Re: Mesa del Sol Tract A - Mixed-use Multifamily DFT Comment Response

The letter outlines the project team's responses to the comments from the Development Facilitation Team received on May 30, 2023 on PR-2023-008551 SI-2023-00778 Site Plan DFT for a mixed-use multifamily development on Mesa del Sol Tract A. The DFT comments are in bold, and the responses are in italics.

DRAWING NAME  
**BUILDING D - EXTERIOR ELEVATIONS**

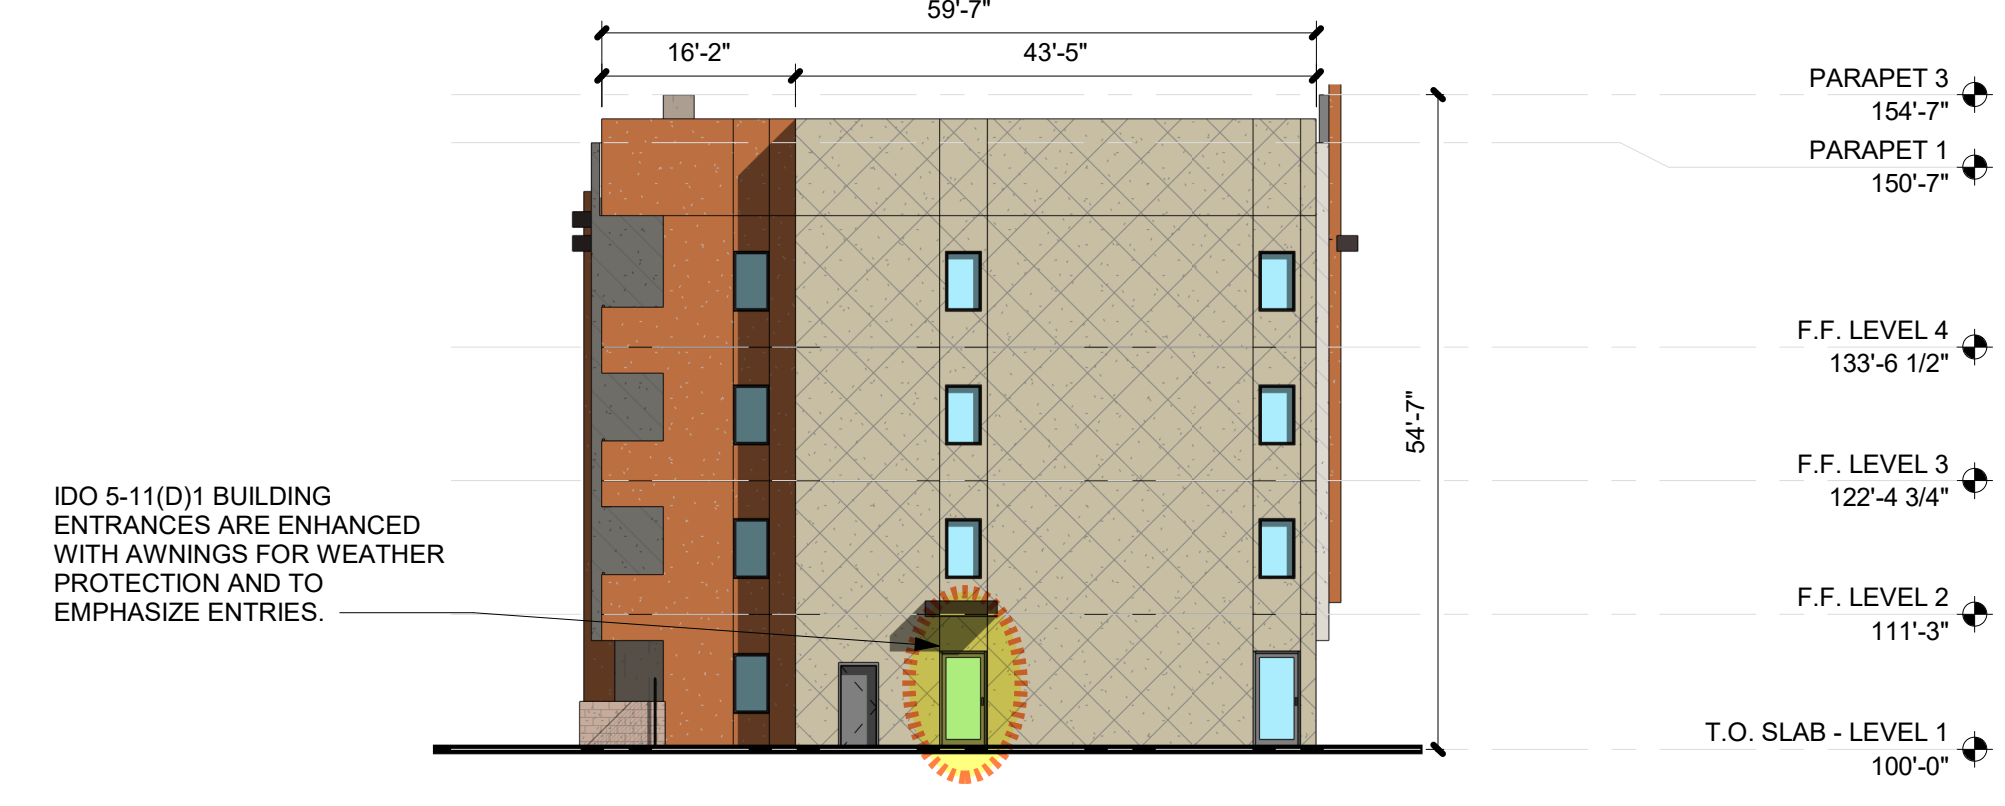
Buildings A through C emphasized the primary entrance through an overhang. Buildings D and E front entrance is unclear.

The primary entrance to Buildings D includes an overhang that provides weather protection and is emphasized by a change in stucco color surrounding the door. The primary entrances to Buildings E are located at the walkway that leads to the stairs that access the upper floor
